Engineers Comments Regarding Surface Water Drainage

Application Reference:	AL/56/26/HH	Reviewer Reference:	ADC/KW/PC
Planning Officer:	Jonny Cooper	Date of Review:	07/08/2026
Site Name:	32 Ivy Lane, Westergate, PO20 3RE		
Application Description:	Demolition of existing storage buildings and construction of 6 No. dwellings and associated works (resubmission following P/43/25/PL).		
Assessment Number:	1 of 1

PROPOSED GROUND FLOOR PLAN

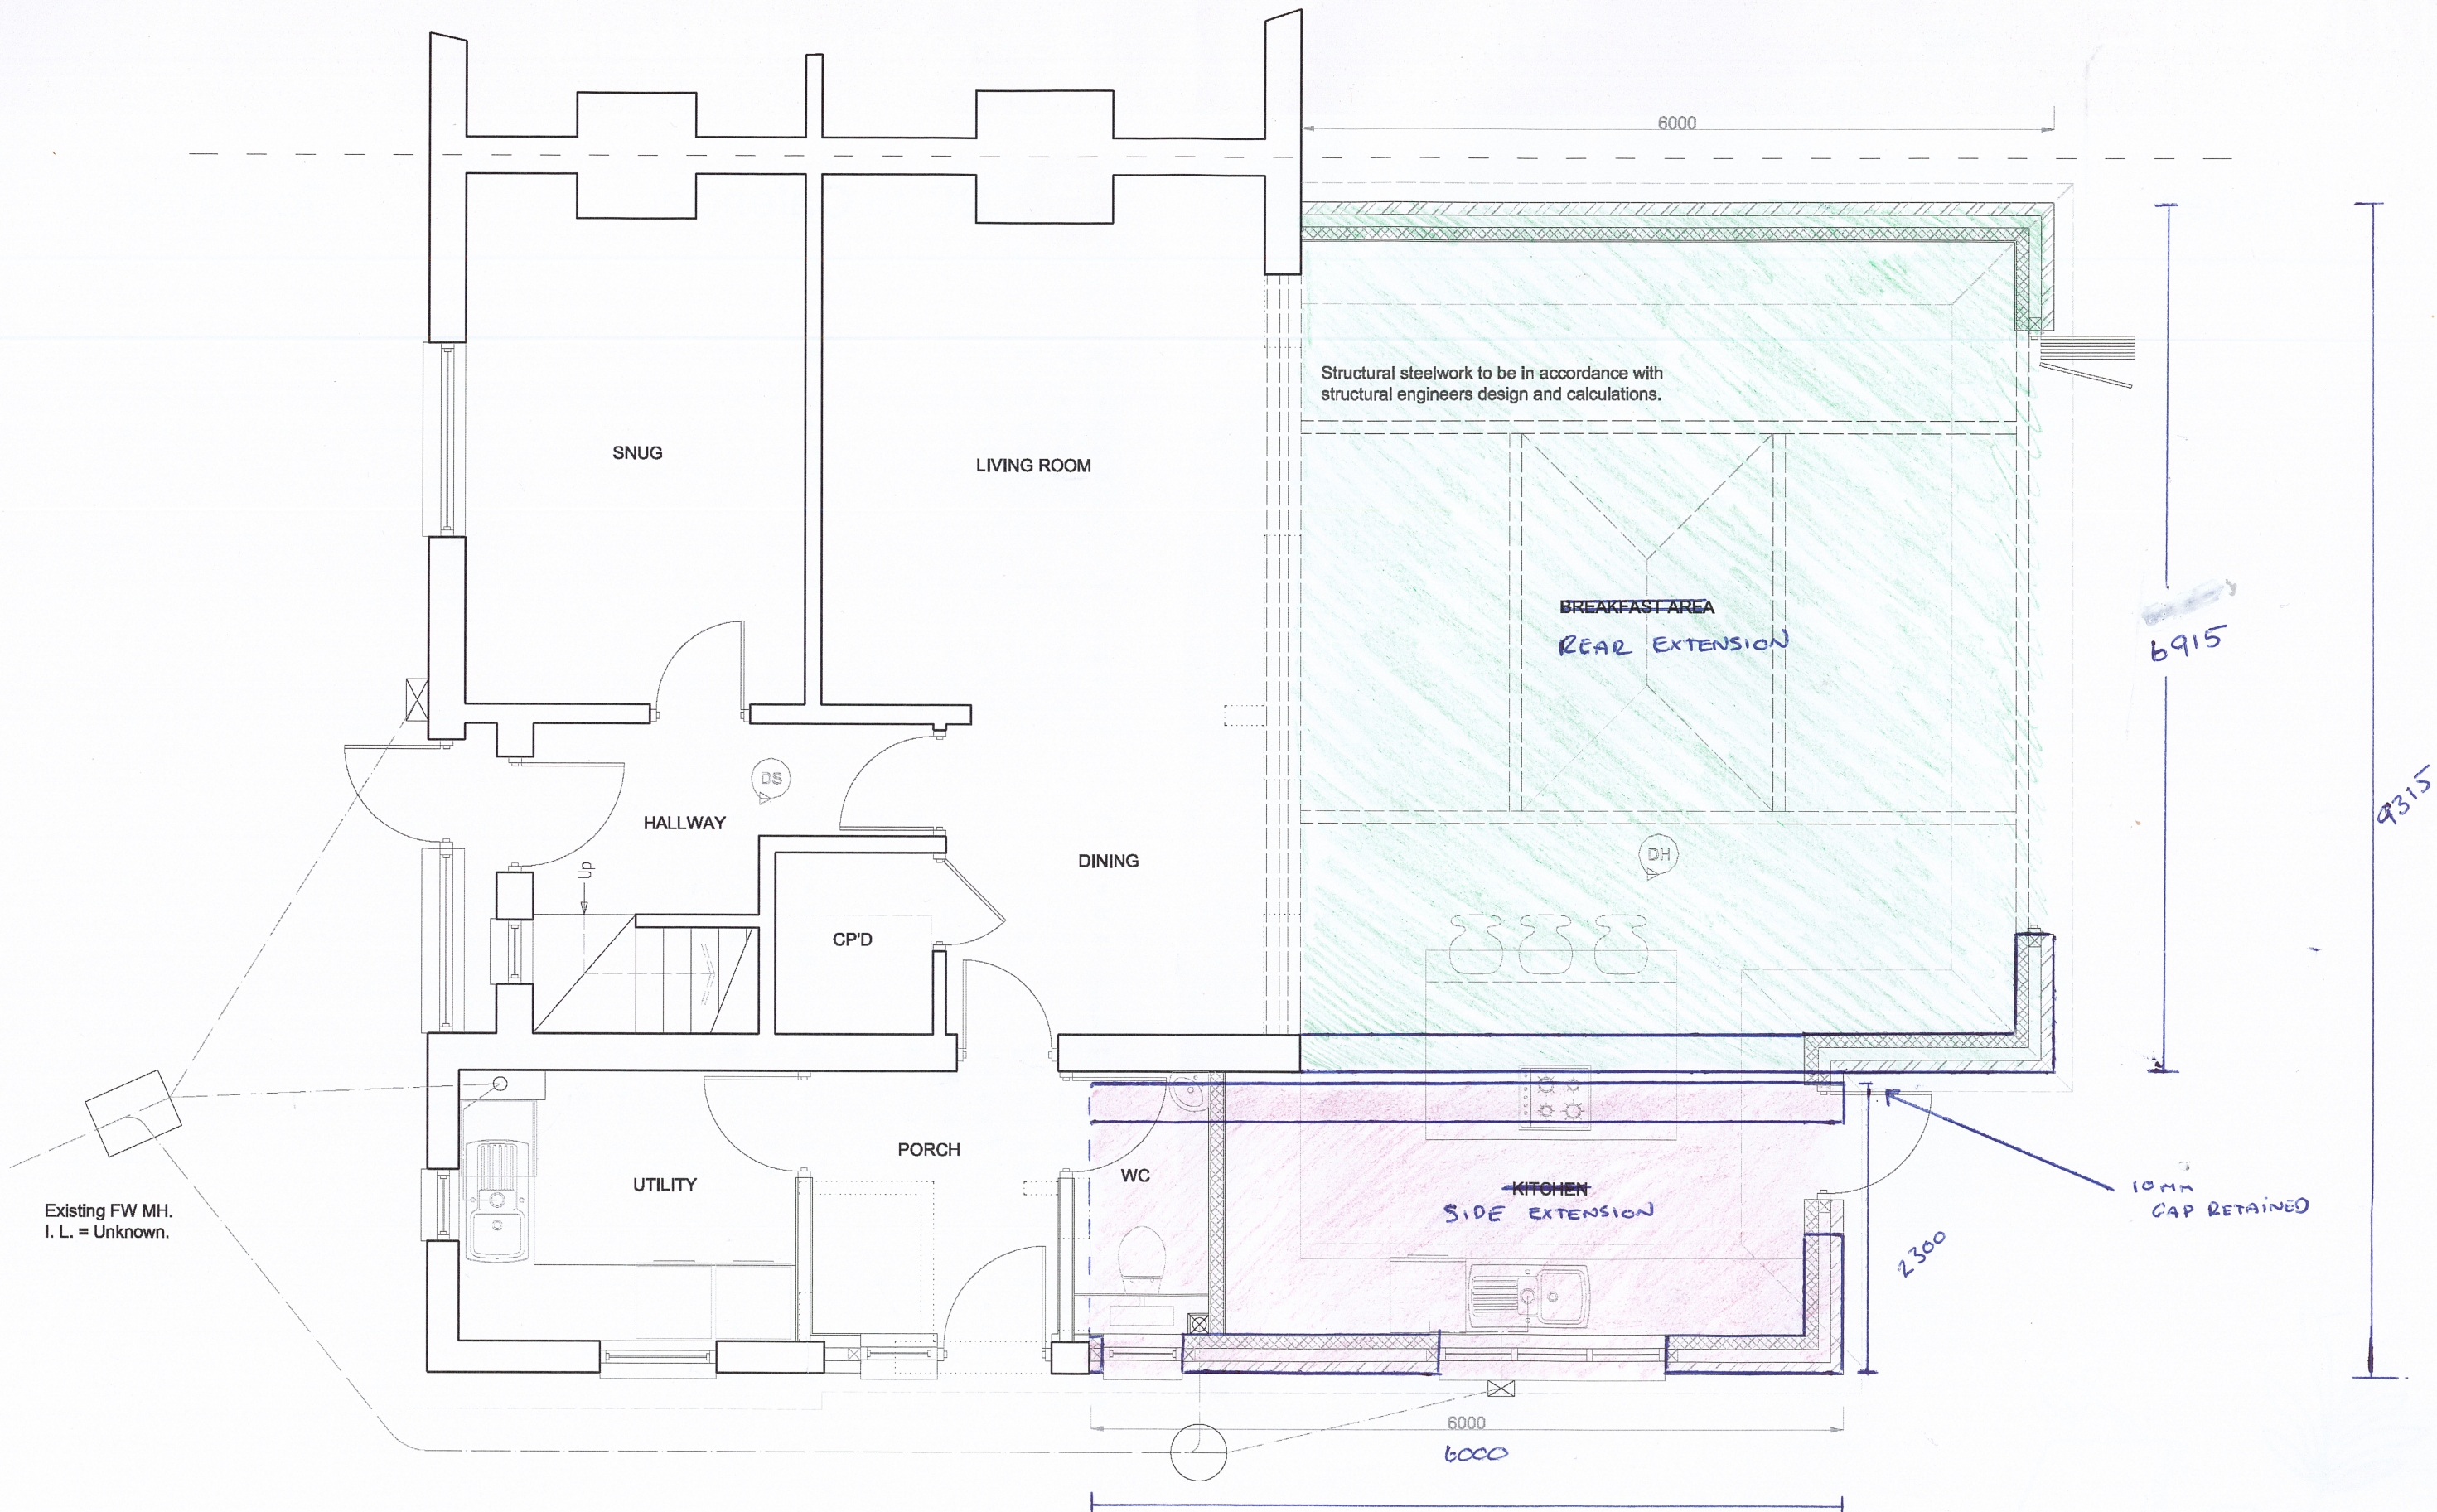
2.1 Discharge to the ground is proposed via a new soakaway located in the rear garden, and we support this approach in principle, as infiltration is the highest priority in the drainage hierarchy after water reuse and aligns with Standard 1 of the National Standards for SuDS (NSfS). However, the necessary evidence to demonstrate that infiltration is viable has not been provided. Fundamental information, such as groundwater monitoring data and infiltration testing results, have not been provided. Furthermore, should infiltration be proven unviable, no alternative discharge location has

been identified. Consequently, it has not been demonstrated that the site can be sustainably drained, and we object to the proposal.

- 2.2 To achieve an infiltration design, winter groundwater levels must be monitored to ensure that 1m of unsaturated ground is allowed for between the base of the soakaway or infiltration structure and the peak groundwater level. Ground conditions and infiltration potential are very variable in Westergate. Infiltration can be possible, but in parts, groundwater can be high or infiltration rates so low as to make infiltration unviable. This must be demonstrated by the applicant.

3.1 The drainage statement has not proposed any interception features. Should infiltration be demonstrated to be unviable, then additional interception feature will be required. In recognition that the National Planning Policy Framework states that SuDS should be proportionate to the nature and scale of the proposal we are willing to accept that the following interception features can demonstrate compliance without further detailed assessment.

4.1 At present, no modelling or supporting evidence specific to this development; such as ground investigations or drainage plans have been submitted for engineering assessment. In the absence of this evidence, we cannot assess if flood risk will be increased by the proposed development. Therefore, this application does not accord with the NPPF as set out above and **we object** to the proposal.
